## ASSESSMENT REPORT

### Block 11 - Central Park, Chippendale (Former Carlton United and Brewery Site) SSD 6376 MOD 1

On 8 August 2016, the applicant lodged the modification application (SSD 6376 MOD 1), subject to this assessment, seeking approval to:

Figure 2: Pedestrian wind speed measurements locations at ground level around Block 11

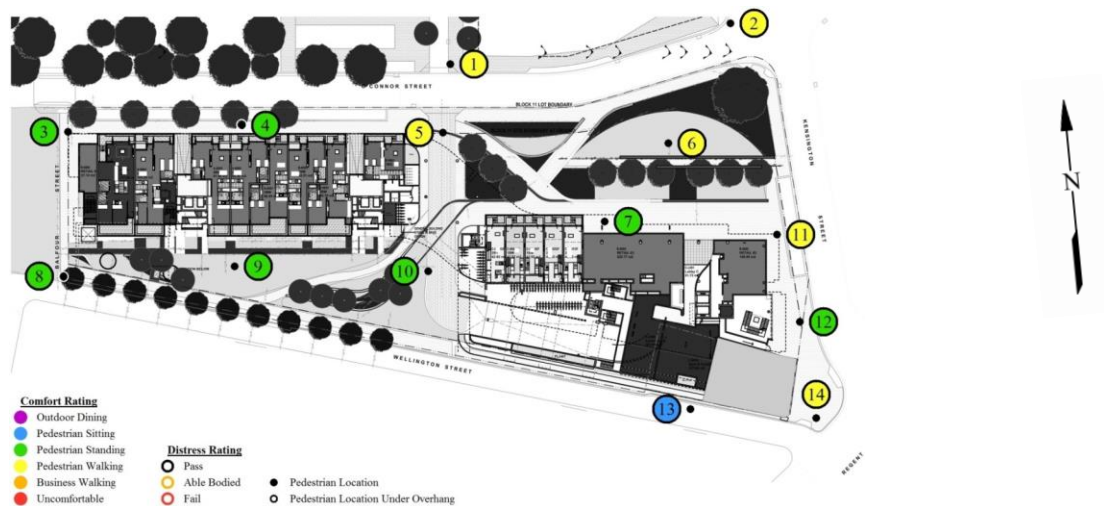
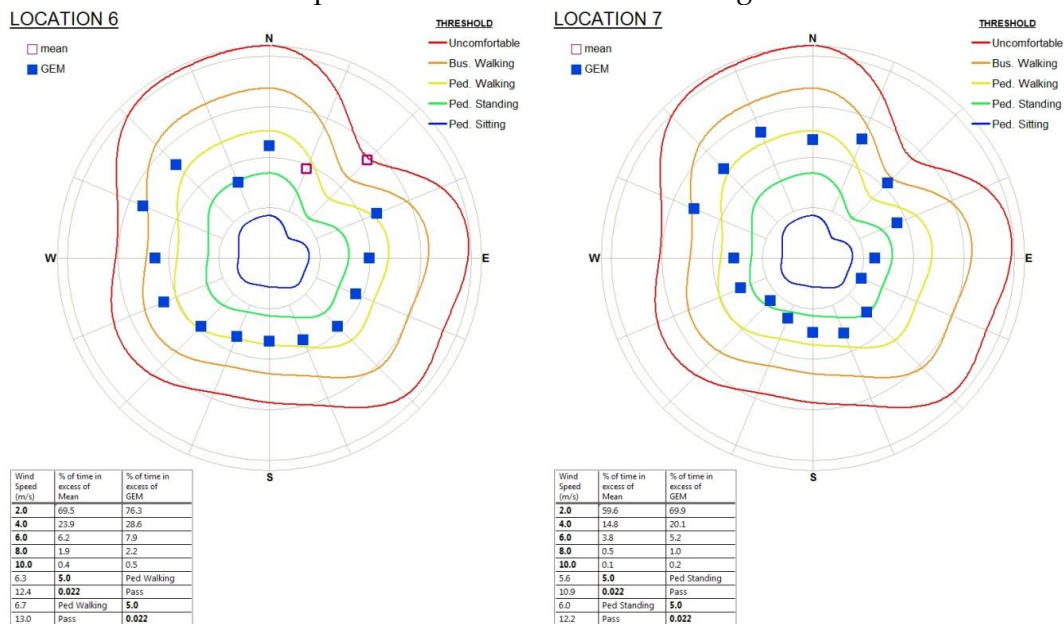
As proposed, the planting within O'Connor Street Park, achieves a wind environment providing a 'pedestrian walking' comfort level, similar to a number of other inner city parks, such as Tumbalong Park. The Department notes the Wind Report states that to meet a 'pedestrian sitting' comfort level within the park as required by the condition, mature trees would need to essentially cover the full extent of O'Connor Street Park. This would result in other adverse amenity impacts, such as loss of solar access, which would also reduce the utility of the park for passive recreation.

The Department considers additional wind amelioration measures would not be practicable in this instance for the following reasons:

- the significant tree planting required to reduce wind impacts would reduce usable open space, solar access and safety and security within the park. Therefore, compliance with the condition would potentially result in a net loss of amenity;
- despite not having a suitable wind environment for pedestrian sitting, the park would still provide a pleasant place to sit on non-windy days, a suitable space for passive recreation, a pleasant pedestrian connection and landscaping which complements other nearby open space including the adjacent Chippendale Green;
- the wind environment is similar to many other open spaces within inner city locations where the urban form comprises high density development; and
- residents have access to other nearby open space, such as Chippendale Green, which achieve comfort ratings suitable for 'pedestrian sitting'.

The Department also notes that the original concept plan for Block 11 did not include a consolidated park at this location. While the proposal does not achieve the desired wind environment, the park would still provide additional green space within this inner city location for the benefit of the community. On this basis, the Department is satisfied the proposal is acceptable.

Figure 5: General arrangement plan

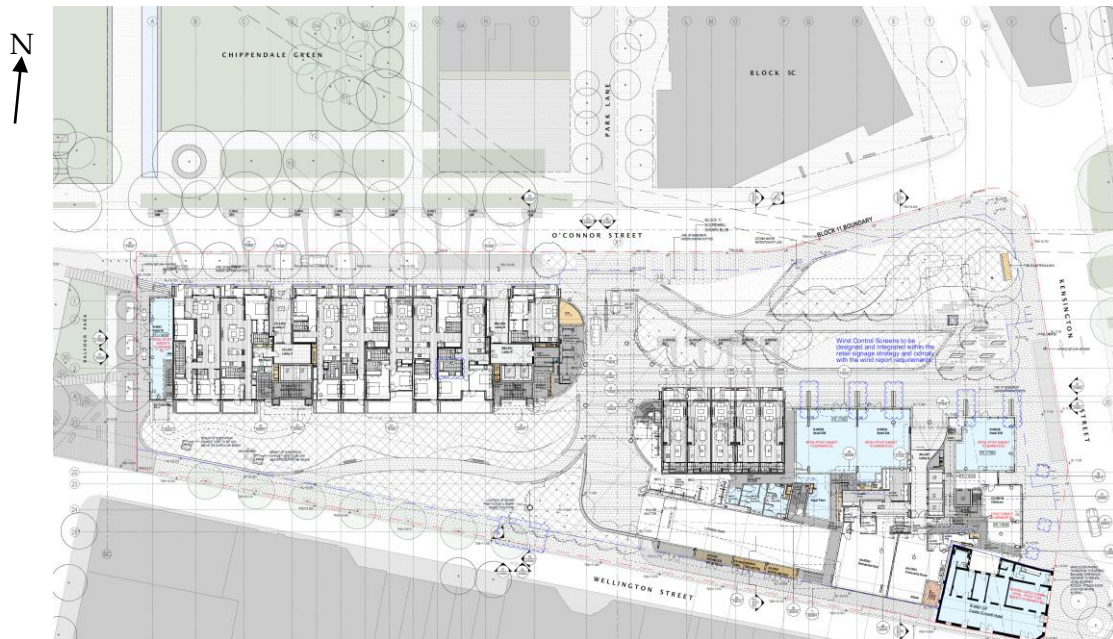
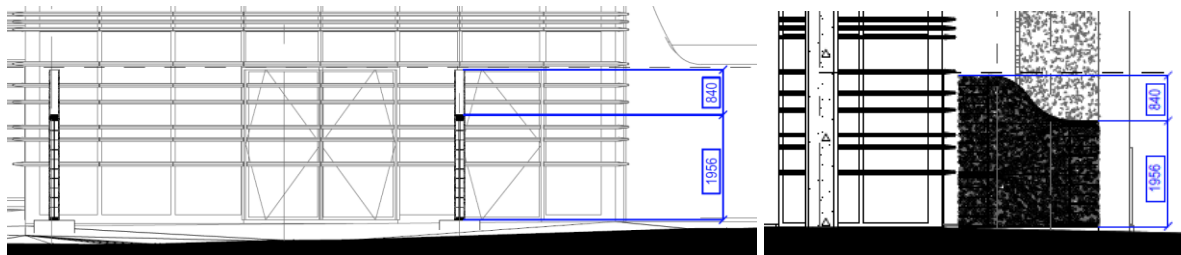
To address wind impacts outside the retail units the modification includes the installation of vertical screens, with climbing plants, angled perpendicular to the ground floor retail unit frontages (refer to **Figure 4 and 5**). The Applicant has stated that subject to the installation of the screens, the areas between them would meet the 'pedestrians sitting' criterion without the need for additional shielding.

To ensure the proposed vertical screens to the retail units do not have an adverse security impact, the Department considers appropriate sightlines should be retained through the screens. The applicant has confirmed while planting is required to mitigate wind impacts, views could be retained through the screens subject to appropriate species selection. The Department has therefore recommended the inclusion of a condition requiring appropriate views be maintained through the screen.

The Department considers the treatments proposed for the retail units and childcare facility adequately ameliorate wind impacts to these spaces and address the aims of Conditions B8 and B9.

Figure 8: Pedestrian wind speed measurements locations at Level 1

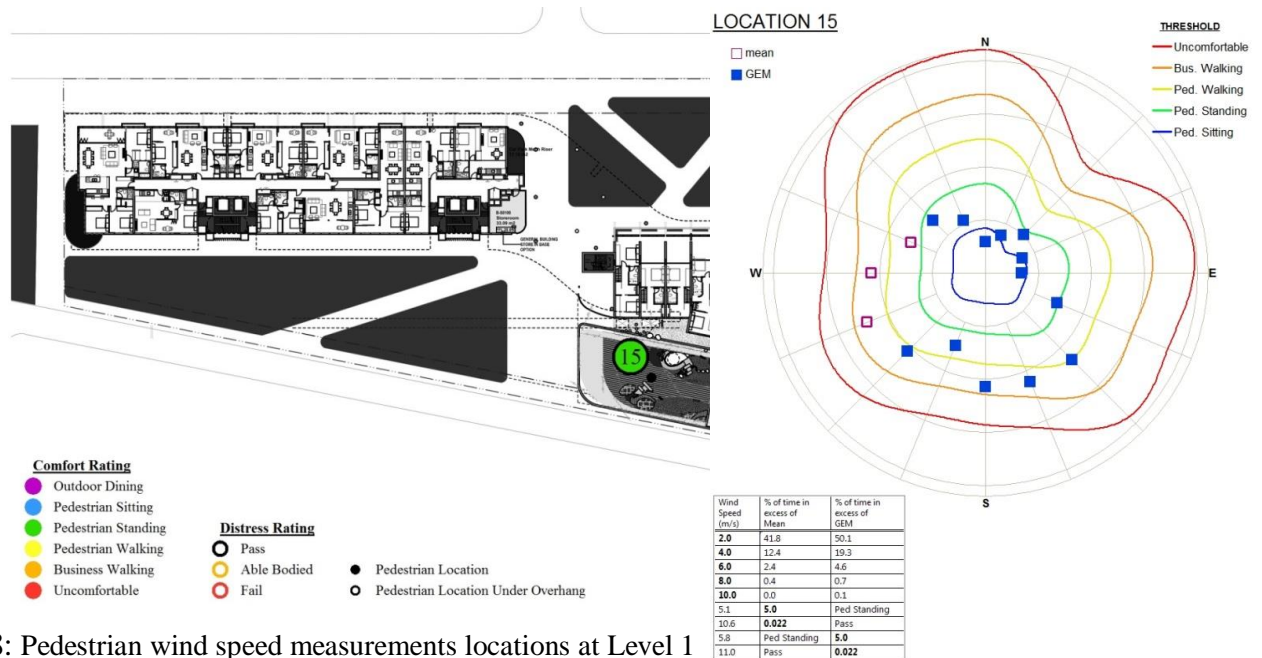
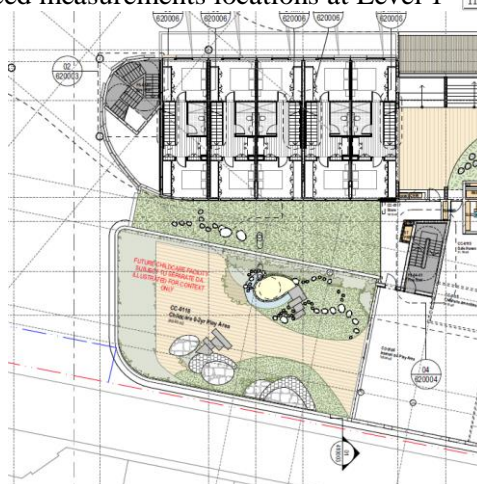
The applicant has also confirmed the outdoor childcare space would achieve a 'pedestrian sitting' comfort level following changes to the geometry of the building and the inclusion of landscaping and perimeter balustrading.
